Recommendation Report for Planning Permission

REF NO: BR/32/25/PL

LOCATION: Trevali Lodge
31 Aldwick Road
Bognor Regis
PO21 2LN

PROPOSAL: External changes, amendments to fenestrations and re-building the garden wall. This application is in CIL zone 4 (zero rated as other development), may affect the setting of listed buildings and may affect the character and appearance of the Aldwick Road, Bognor Conservation Area.

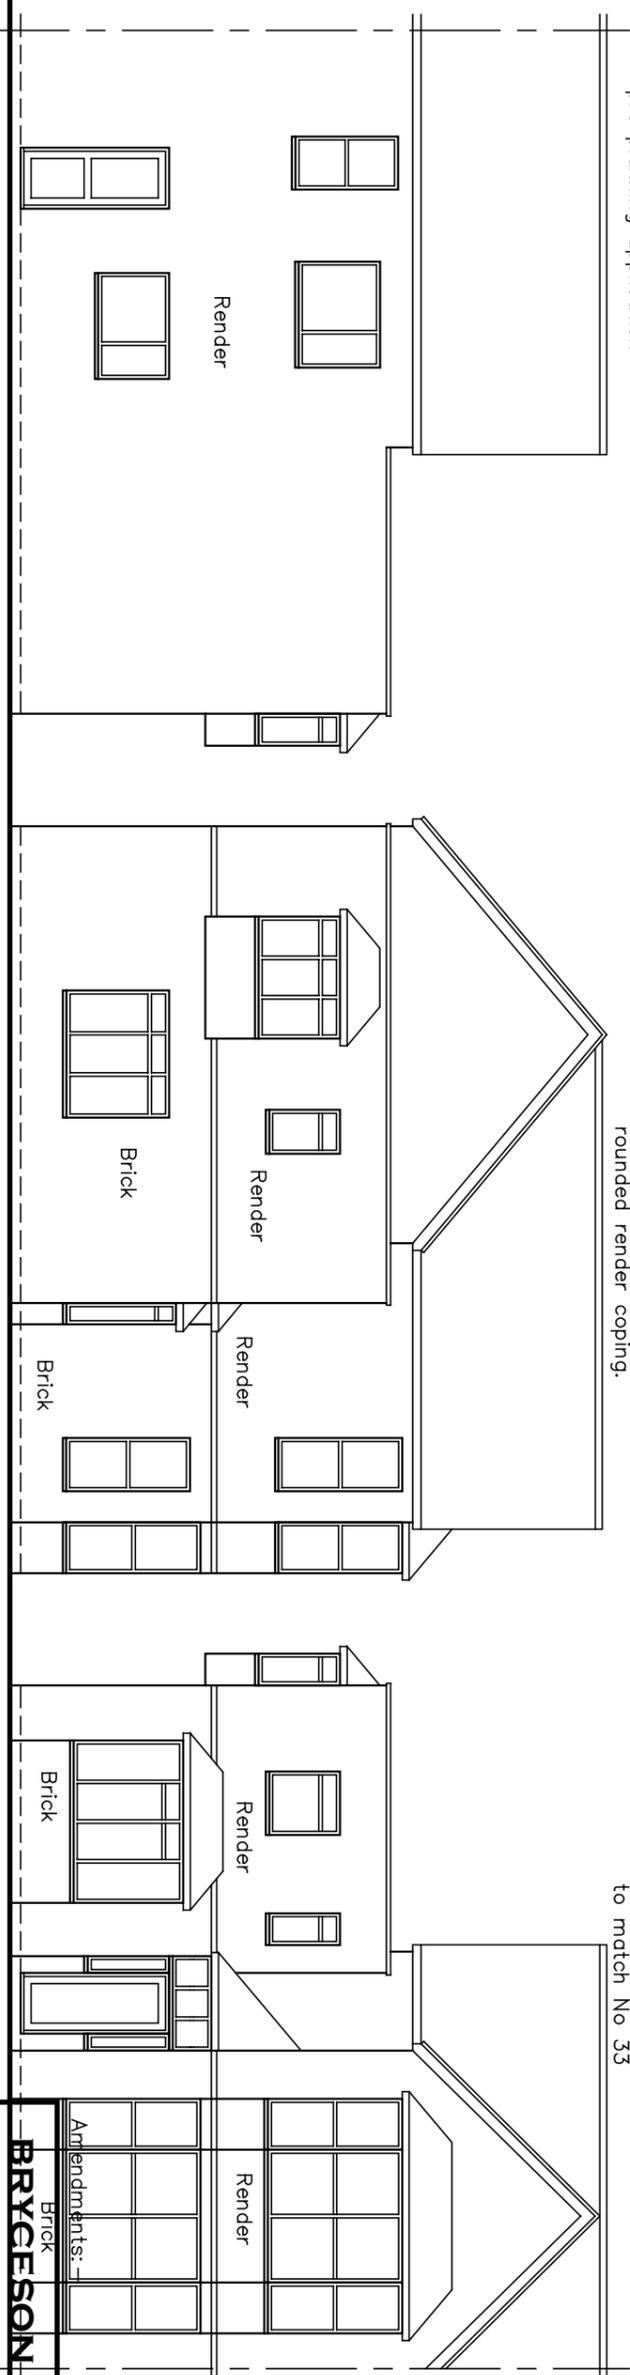
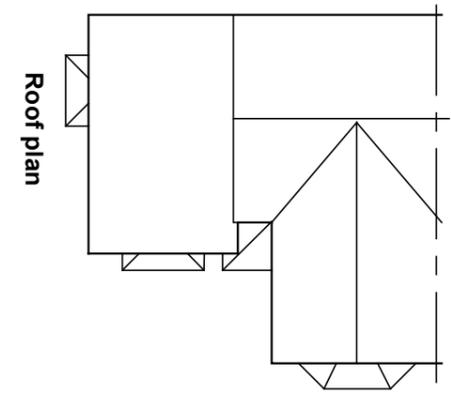
- The existing windows on the principal facade are painted timber vertically sliding sashes and important traditional features which should be repaired or replaced 'like for like'.
- The loss of such traditional features is detrimental to the appearance of a conservation area.
- The replacement UPVC vertically sliding sashes will detract from the appearance of the property and the conservation area.
- Concerns regarding the potential for white UPVC fascia, soffits, and gutters.
- Concerns regarding the loss of the flint boundary wall and that the replacement with a brick wall is insufficient.
- A sample panel of flint walling should be provided if agreed.
- Welcome some of the changes made since the last application but the proposal is still detrimental to the appearance of the building and the conservation area.

- It is positive that the external walls of the house will no longer be altered, and that repairs would be undertaken to the existing materials.
- Appropriate and matching materials should be used.
- The use of UPVC windows is disappointing and their opening mechanism and appearance is unclear.
- If you UPVC is found acceptable, a condition for further details is suggested.
- The former flint wall was attractive and the reason for its loss is unknown.
- If the new wall cannot be constructed using individual flints, then the use of bricks might be acceptable in this instance subject to condition.
- On balance, the proposal could have a neutral impact and, therefore, in this particular instance, not cause harm to the significance of the heritage asset.

The replacement of the painted timber vertical sliding sash windows with white UPVC alternatives is an unfortunate loss of the original character of the building, however, the harms are limited due to the proliferation of white UPVC windows within the immediate vicinity and on the adjoining neighbour building which appear to have emerged over the years and now inform the immediate context of this unit. As such, the replacement of these windows with UPVC alternatives of a suitable design and style is accepted, and an appropriate condition to secure and control the details of these units has been attached.

The rebuilding of the flint wall to the east side of the plot is appropriate and welcomed. Whilst the reasoning for the loss of the former wall is unclear, subject to appropriate condition, the flint walling can be reconstructed to an acceptable quality to remediate the harm caused by the loss of the former wall.

The rear bifold doors are a significant contrast to the limited openings of the buildings former state, however, they remain would mostly concealed from the wider public realm and read within the context of UPVC fenestrations of neighbours to the rear. This component is acceptable.

Comments noted. The boundary wall to be rebuilt has been revised to reflect the use of flint and lime mortar.

During the lifetime of the application, the boundary wall to be rebuilt has been amended from brick to flint, and clarification has been given with respects to the proposed fascia, soffits, and gutters in that they are all to match the existing building.

The rebuilding of the side boundary wall is positive. It had originally been proposed to be of brick construction however, following agreement, it has been agreed to consist of individual flints and lime mortar with rounded render coping which is reflective of the former boundary wall and subject to appropriate condition, would be of an appropriate detail. Whilst the reasoning for the loss of the former wall is unclear, it is positive that the wall is now to be replaced.
